WSCC CONSULTATION RESPONSE:
County Planning – Minerals & Waste Planning Authority

TO:	Arun District Council Case Officer: Raymond Cole						
DATE:	25 June 2020						
LOCATION:	Ford Airfield Market, Ford						
SUBJECT:	F/5/20/PL - Reconfiguration of Ford Market, including revised market access, hardstanding for replacement vehicular parking and associated infrastructure, landscape, ancillary and site preparation works.						
RECOMMENDATION:

These comments follow the submission of a Waste Infrastructure Statement (dated May 2020) prepared by the applicant. They should be read in conjunction with comments made on 2 April 2020.

FIGURE 4: PROPOSED SITE PLAN

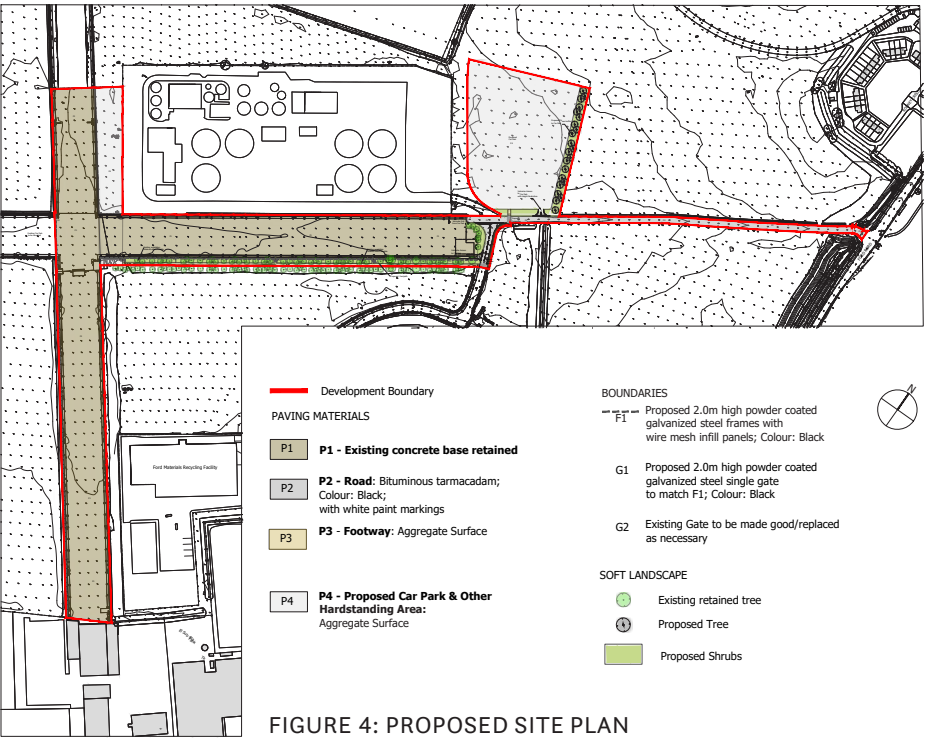
It is of note the submitted plans do not detail the existing access (and associated landscaping/drainage) to the CTP site, which is both implemented and in use. Submitted assessments do not take into account relevant EIA assessments provided in support of developments at the CTP site, or neighbouring waste sites, or controls attached to permissions thereto (e.g. routing, hours and volumes of HGV movements).
